KITTITAS COUNTY COMMUNITY DEVELOPMENT SERVICES

Subject: Jerke Short Plat Final (SPF-19-00003) – Staff Review and Request for Additional Information

DWN BY	DATE	JOB NO.
G. WEISER	8/2019	17195
CHKD BY	SCALE	SHEET
M.K.K./D.L.P.	1" = 100'	1 OF 3

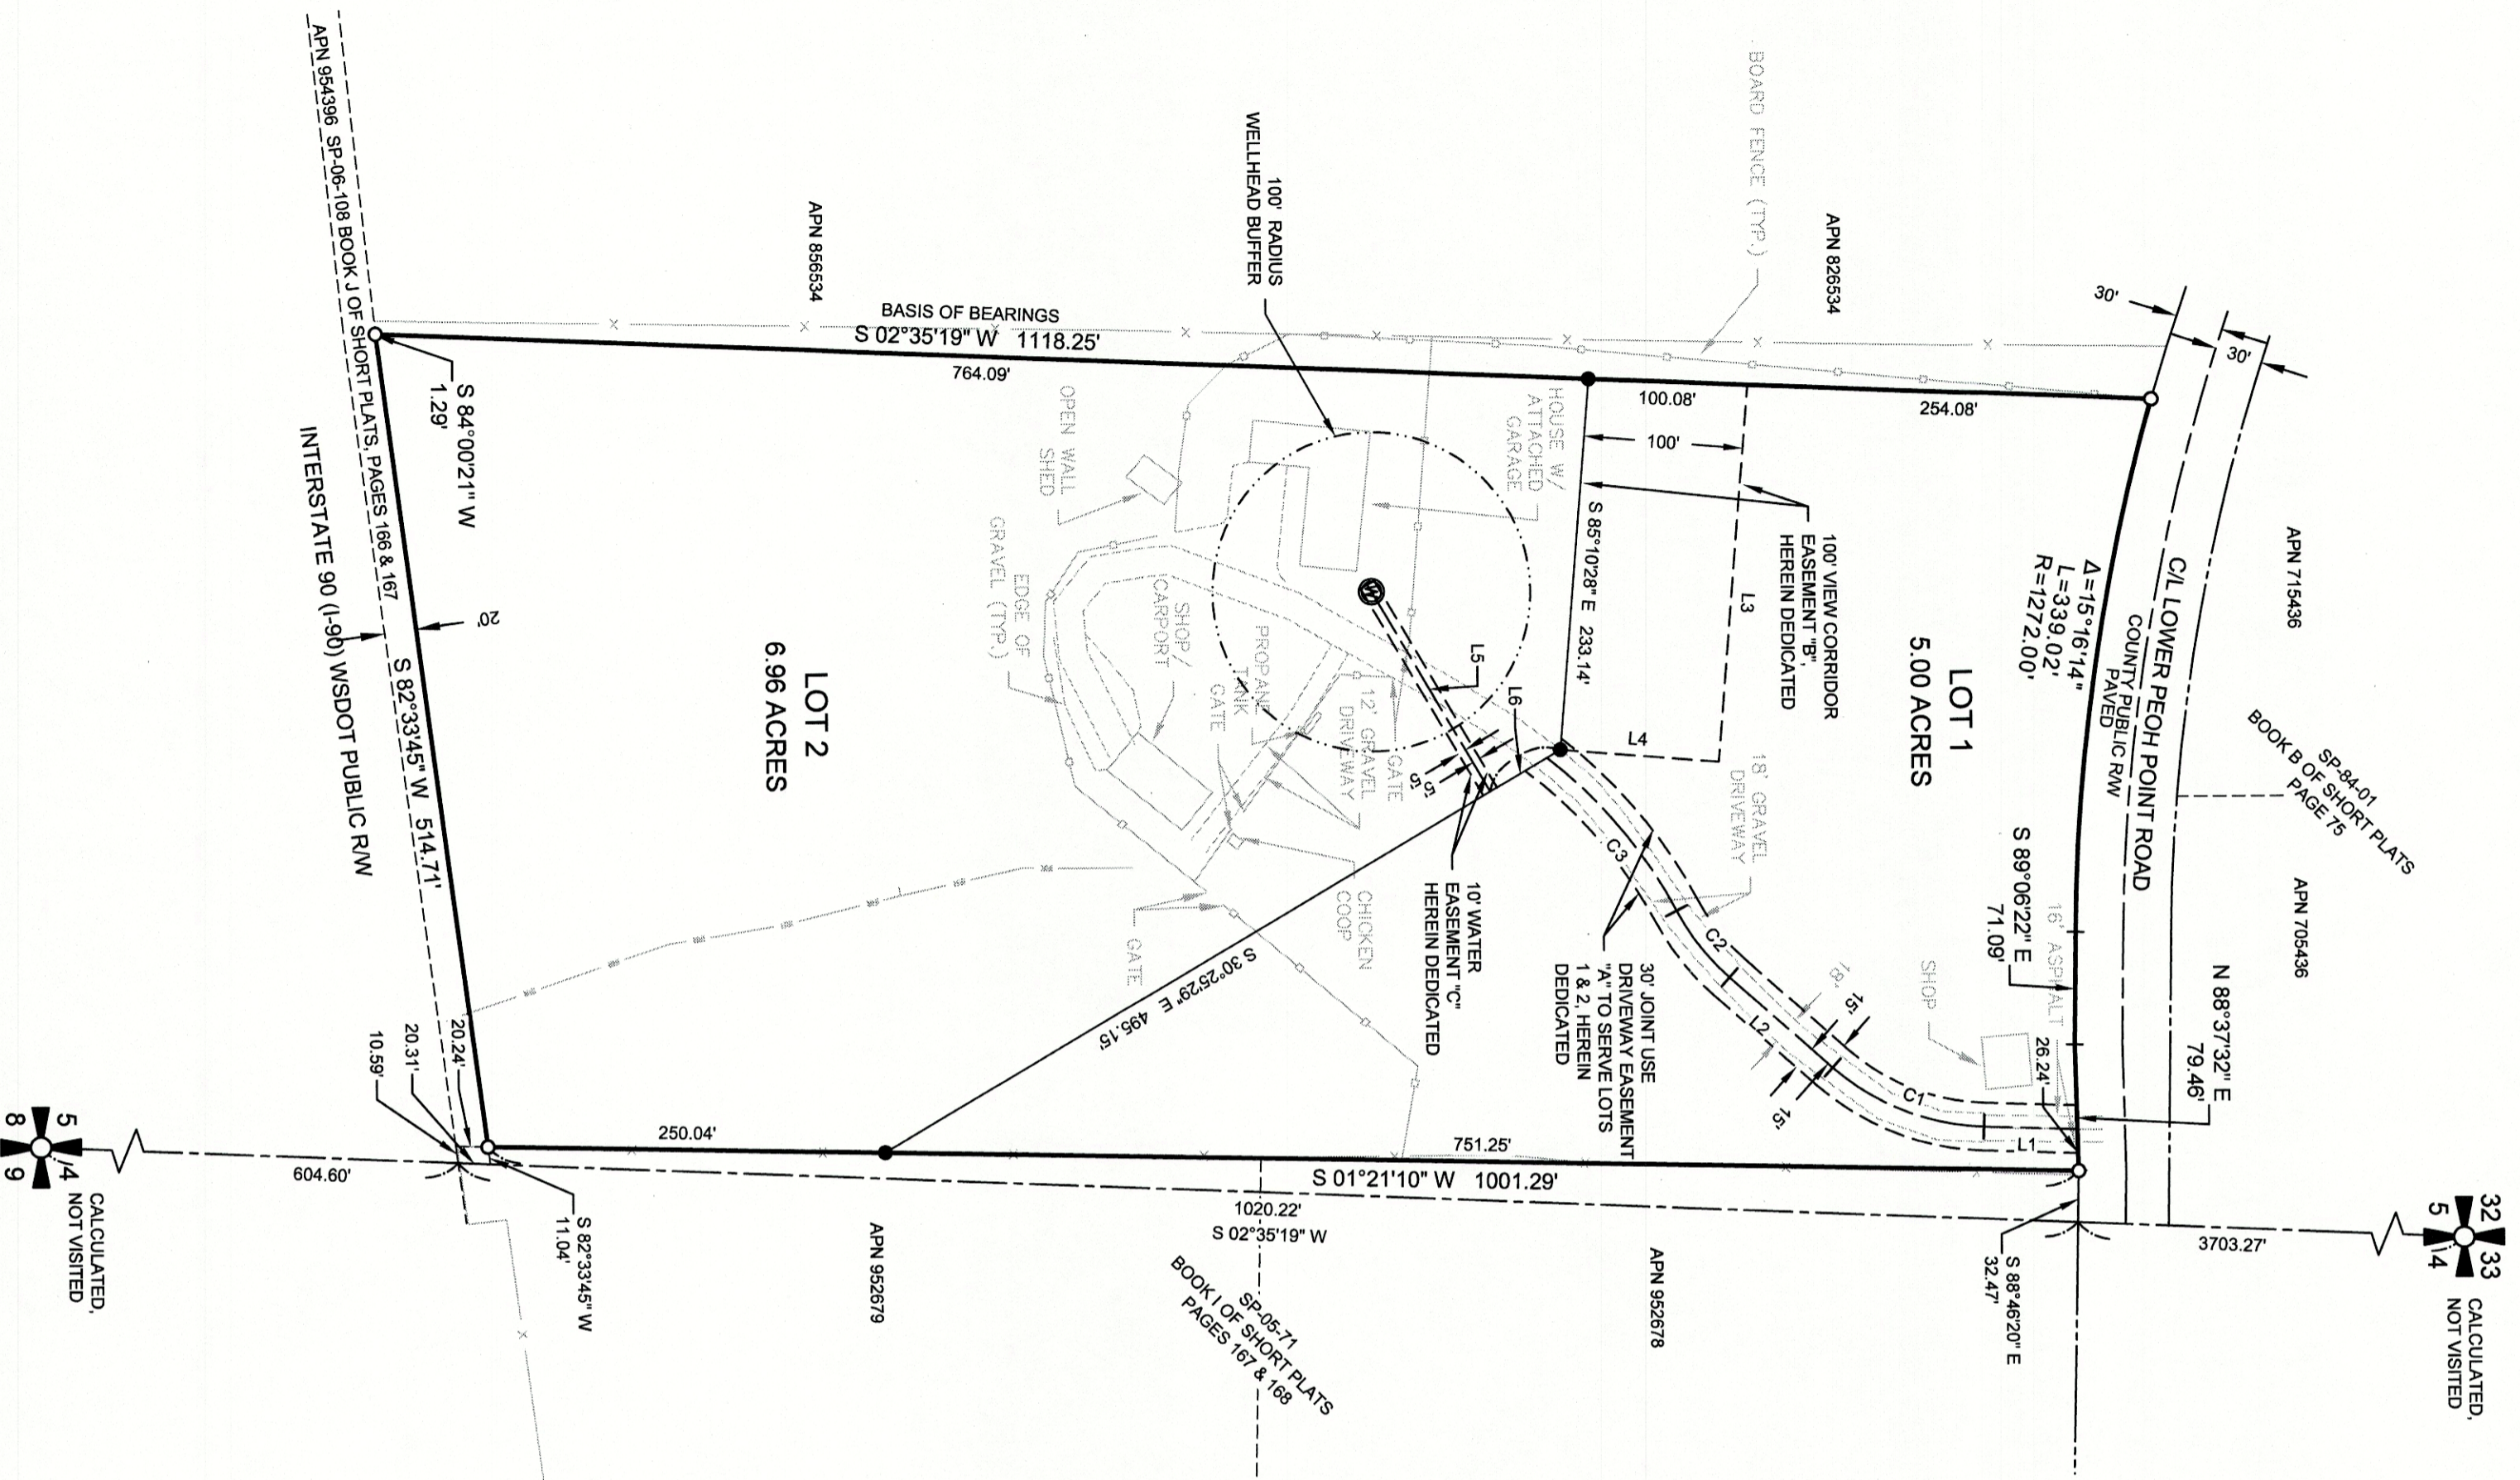
- The final short plat number "SPF-19-00003" shall be present on the face of the plat.

- Grey scale line work is not allowed
- Basis of Bearing on map does not match survey notes on sheet 2
